From: Laura Gibbons
Sent: 23 November 2018 12:41
To: Planning.Responses
Cc: Anita Gardner
Subject: RE: Planning Consultation on M/137/18/DOC

Engineers Comments Regarding Condition 4- drainage

APPLICATION M/137/18/DOC

Site Address: 74 Elmer Road Middleton on Sea PO22 6EY

OPTION 1

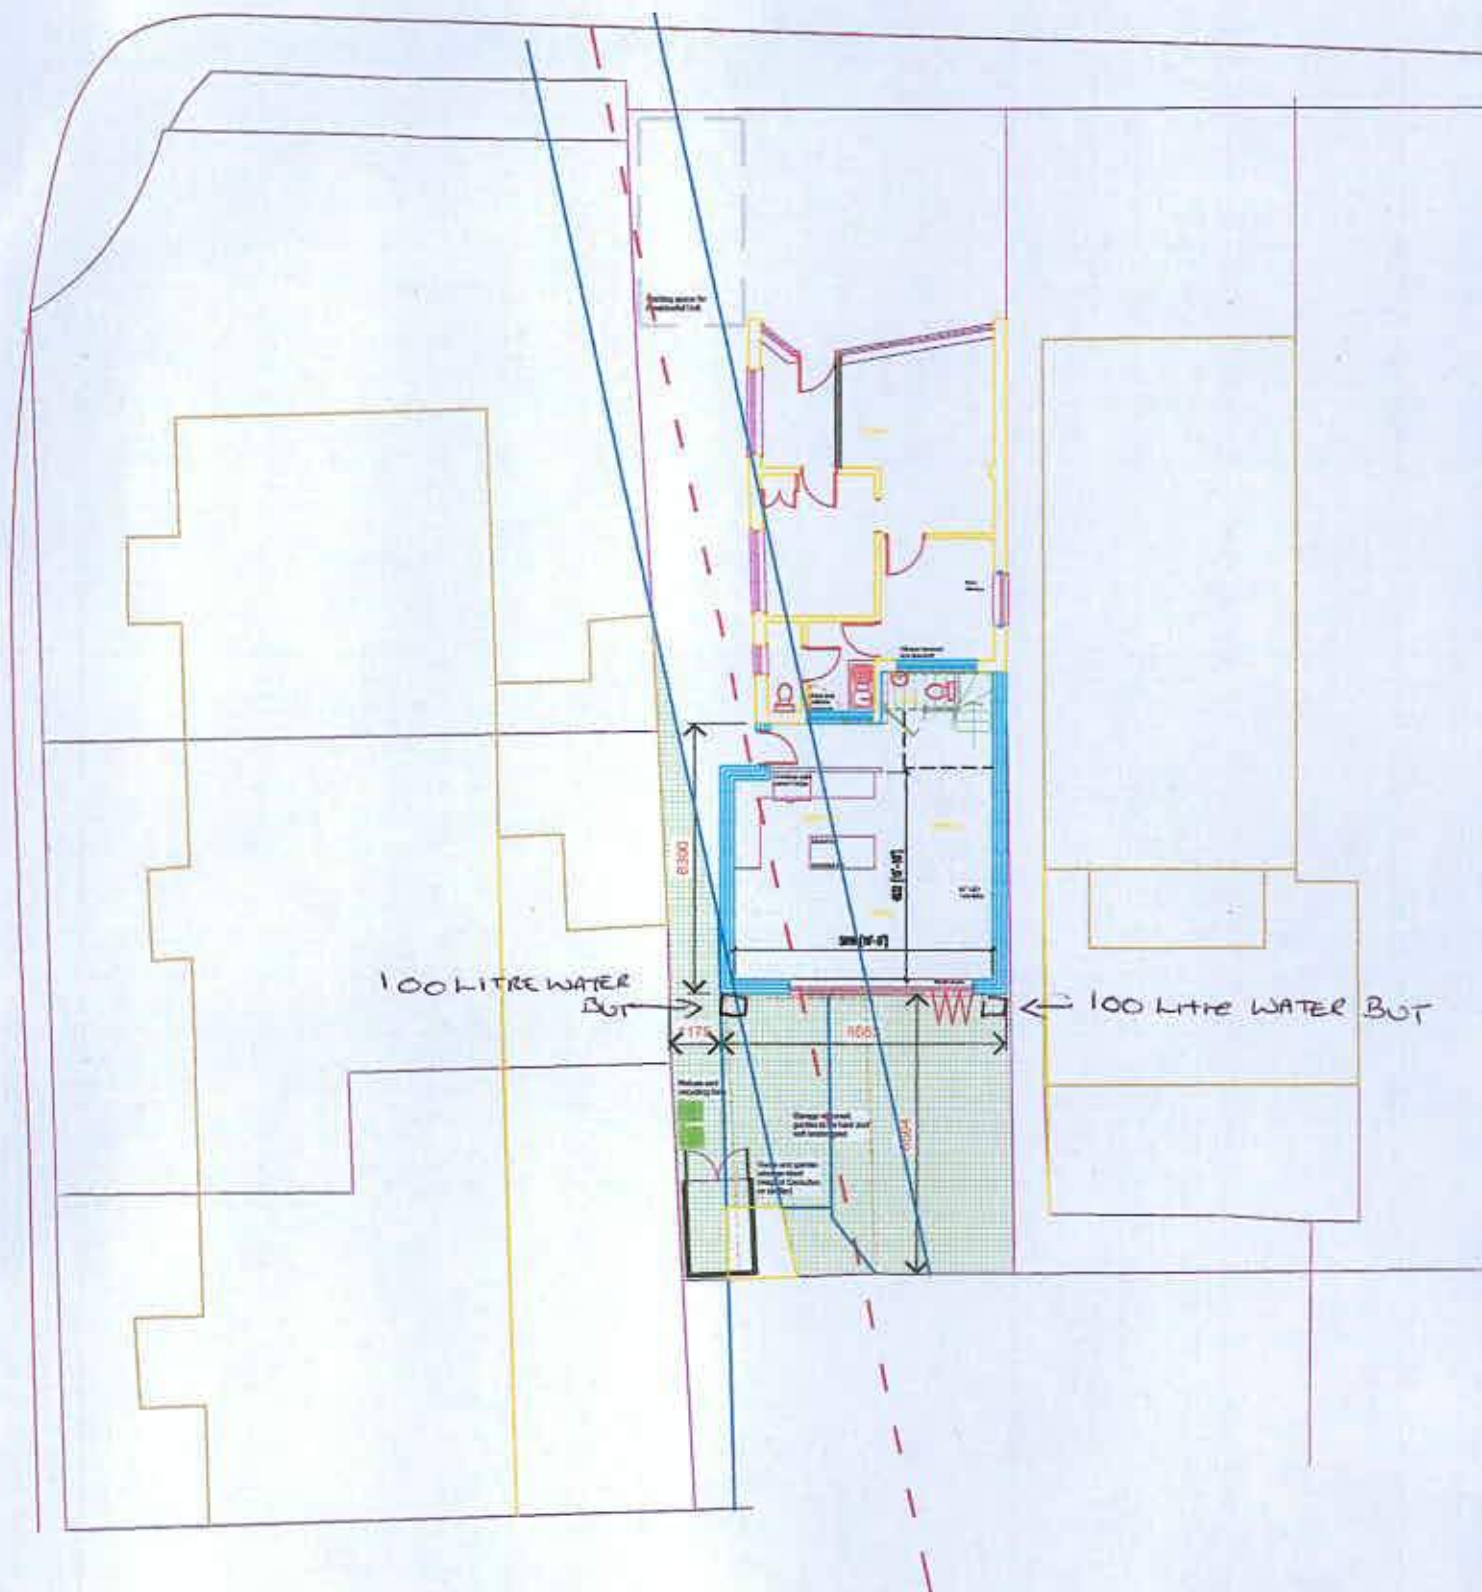
Consultation between the applicant, myself and southern water has occurred to agree the best possible surface water drainage design. Southern water have agreed to the positioning of the soakaway.

Based on the supplied information and discussions I recommend that condition 4 is discharged.
